Subject: Planning Application 3/2025/0107 - Boadicea Park, Preston Road, Ribchester

Once again, Ribchester Parish Council wishes to record its continuing concerns (and strong opposition) in respect of the above planning application. The Councillors have consistently responded at length to the proposals for the development of this site and despite the objections raised, concerns registered and the continuing opposition from residents who are directly affected the work continues to despoil the area off Preston Road.

Proposed Lodge No. 5
 Boadicea Park, Preston Road,
 Ribchester, PR3 3XL

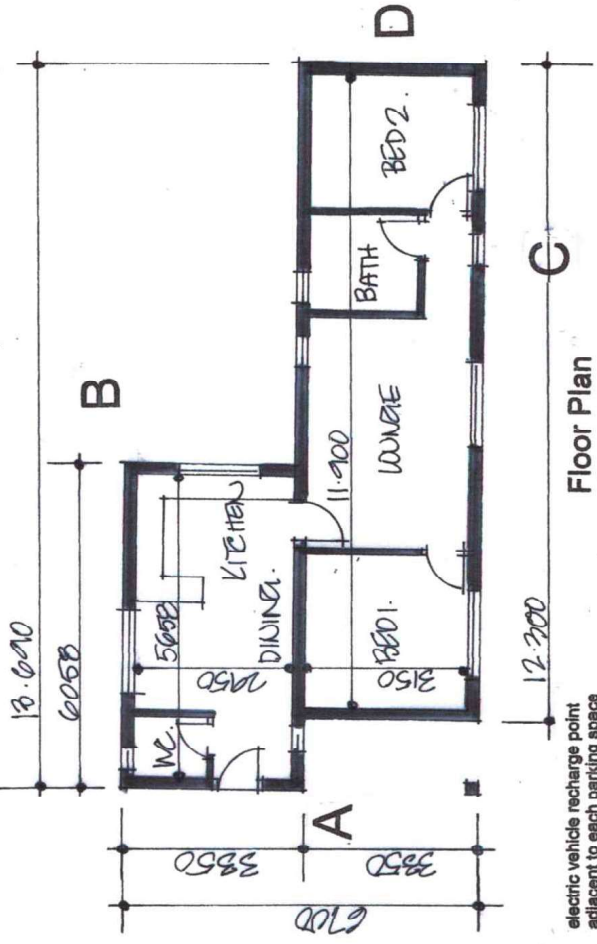
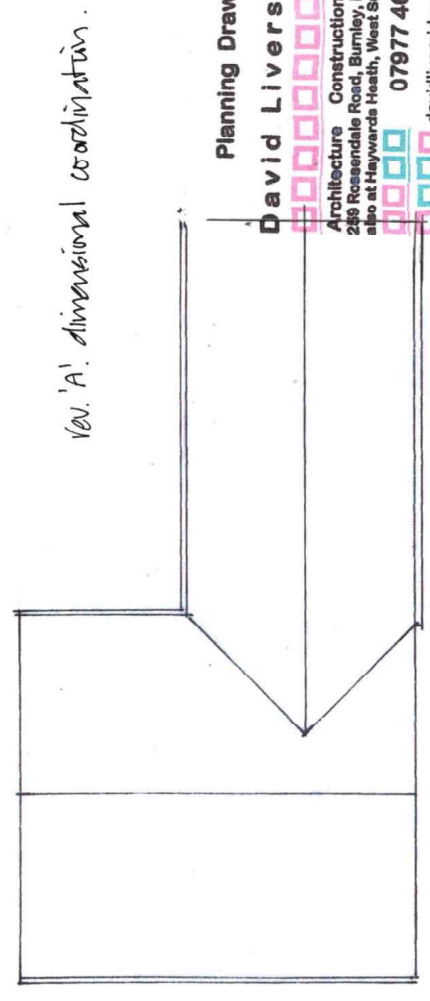
One of the proposed lodges is already in place; it doesn't look especially 'visually consistent' with the existing lodges.

With reference to the previous images, 'local distinctiveness, vernacular style, scale, style, feature and building materials' are not really being protected in this application.

#### Detached Warehouse Quality Control Office

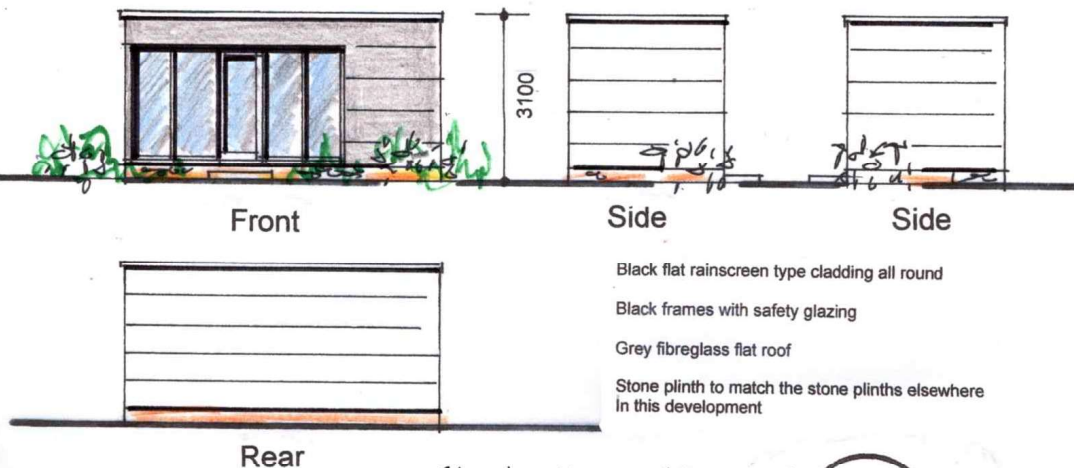
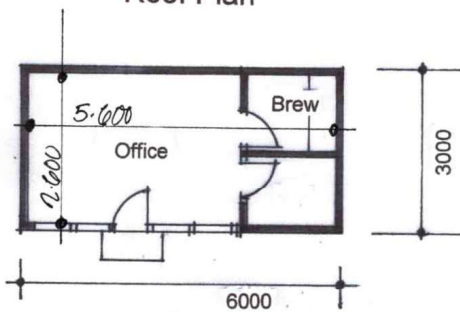
This is indeed the case, although it is set further back towards the river than the plan would suggest.
